Rezoning Transportation Analysis

Petition Number: #2022-079

The petition is located on the west side of Kenilworth Avenue, a City-maintained major throughfare and south of Pearl Park Way, a City-maintained local street. A Traffic Impact Study (TIS) was approved by CDOT on 4-14-23. All outstanding CDOT comments have been addressed.

RZ - 200

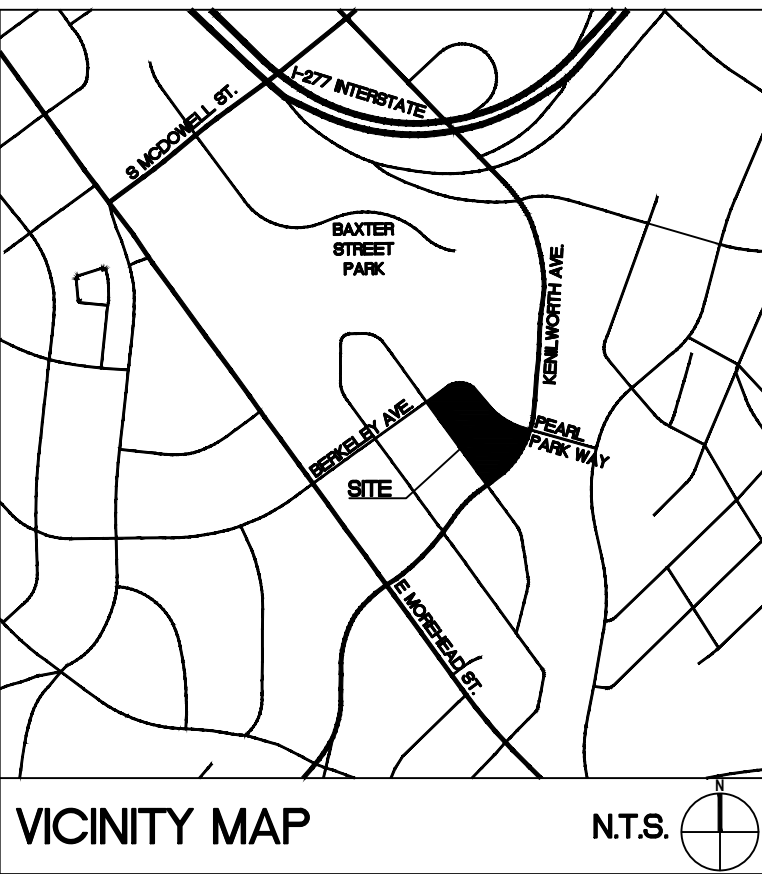
- ~~2. **New Comment 11-27-23:** Revise site plan and conditional note(s) to remove the proposed right-in only access on Kenilworth Avenue. Access on Kenilworth Avenue does not meet driveway spacing requirements with respect to adjacent driveways, distance to signalized intersection, and conflicts with future protected intersection improvement. The site plan should be redesigned to access the site from Kenilworth using the established shared access point south of the petition.~~

- ~~3. Revise site plan and conditional note(s) to provide 8 foot sidewalk and 8 foot planting strip along the frontages of Kenilworth Avenue, Pearl Park Way, and Berkeley Avenue.~~

- ~~4. **Outstanding Comment 11-28-22:** Revise site plan and conditional note(s) to commit to installing the protected intersection project at the intersection of Kenilworth Avenue and Pearl Park Way. Screen in the improvements for the project.~~

- ~~5. **Outstanding Comment 12-22-22:** The two proposed driveways on Berkley Avenue do not meet the minimum 75-foot corner clearance distance from an unsignalized intersection per the *City of Charlotte Driveway Regulations*. The driveways will either need to be consolidated or one of them will be limited to right-in/right-out.~~
